Our ref: RA/2023/146565/03-L01
Your ref: 2023/93388

**CHANGE OF USE FROM DOMESTIC TO COMMERCIAL, DEMOLITION OF
EXISTING WORKSHOP AND ERECTION OF THREE STOREY OFFICE BUILDING
(WITHIN A CONSERVATION AREA) – DENE END FUNERAL HOME, 50 NORTH
ROAD, KIRKBURTON, HUDDERSFIELD, HD8 0RW**

Thank you for re-consulting us on this application following submission of a revised FRA and amended plans, which we received on 7 June 2024.

APPENDIX 2 – Topographical Survey

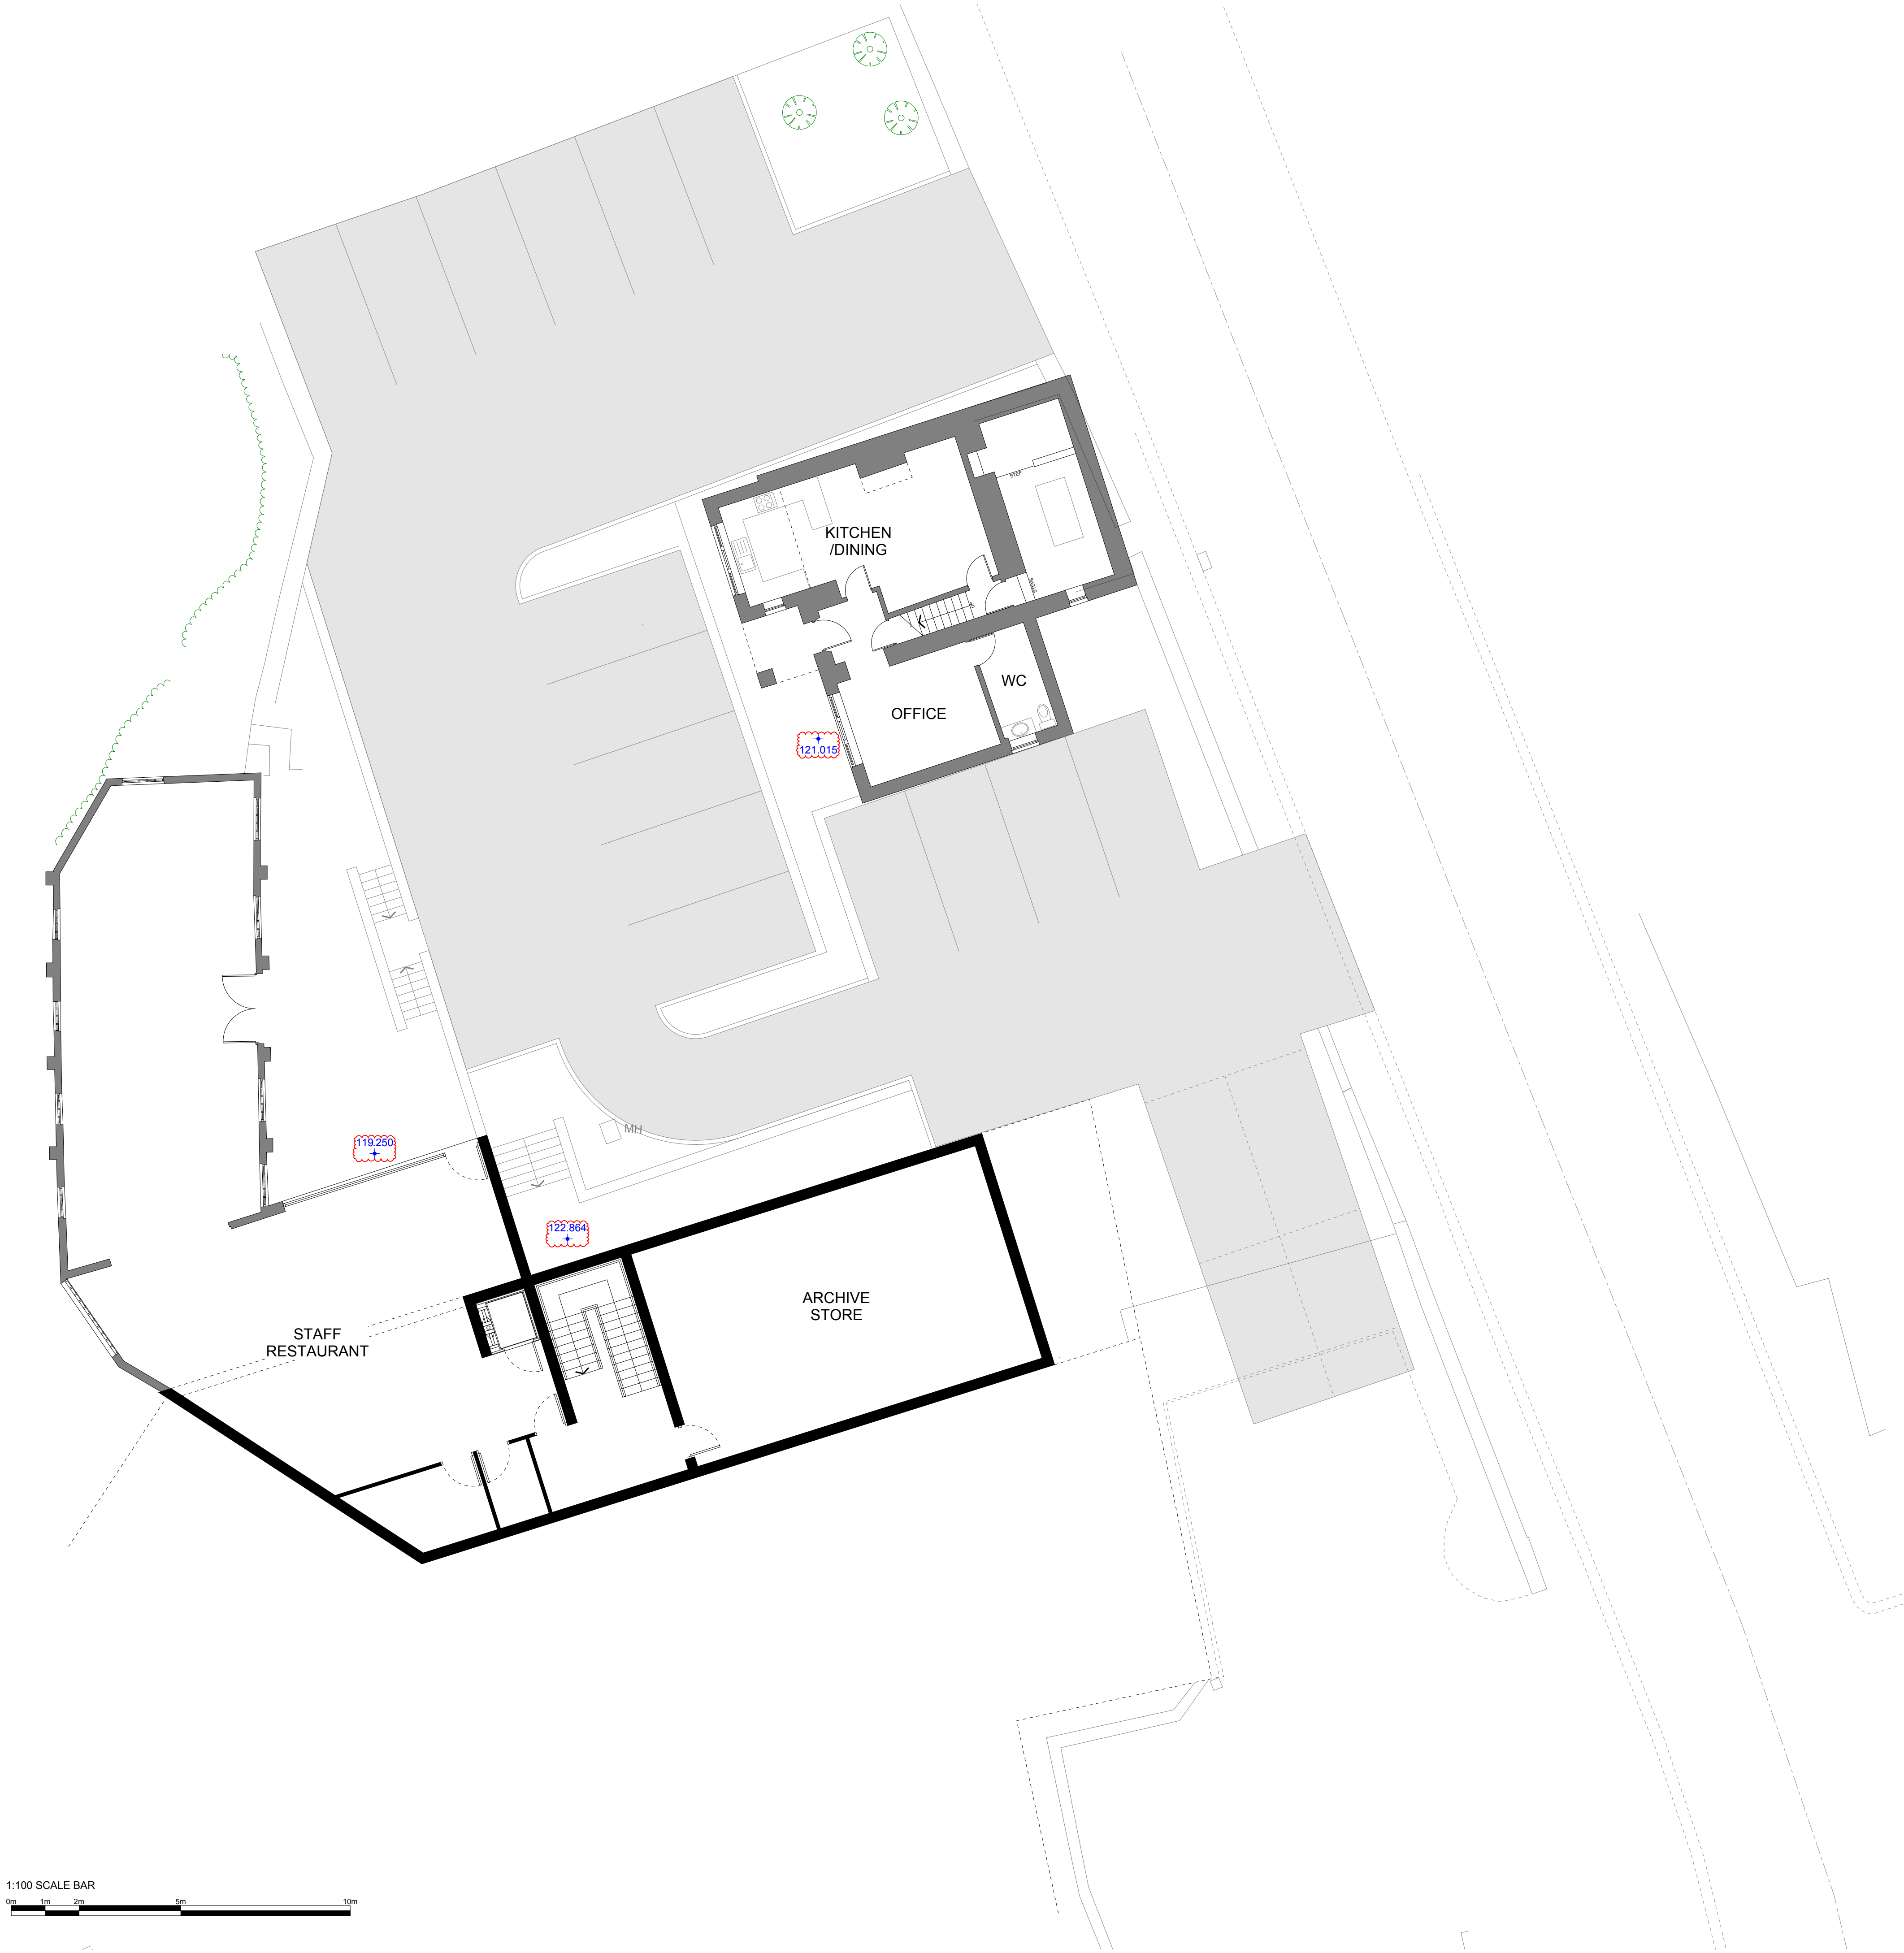
Section 2.4 of the FRA has been updated with new site ground levels, however, these still contradict the levels shown in the topographical survey in appendix 2. Levels shown on the survey are in the approximate range of 95-100mAOD, which is much lower than suggested in Section 2.4. If site levels are as per the survey, then the site would appear to be at risk of flooding in the design flood event. Because it is unclear what the flood risk to the site is, it is not possible to trust the conclusions of the FRA.

- Conclusively demonstrate how a range of flooding events (including extreme events) will affect people and property, because the topographical survey contradicts the site levels stated in the FRA.
- Assess the impacts on flood risk, of works immediately adjacent to a culverted main river, including impacts to the structural integrity of the culvert and impacts to future maintenance access.

To overcome our objection, the applicant should submit a revised FRA which addresses the points highlighted above. If this cannot be achieved, we are likely to maintain our objection.
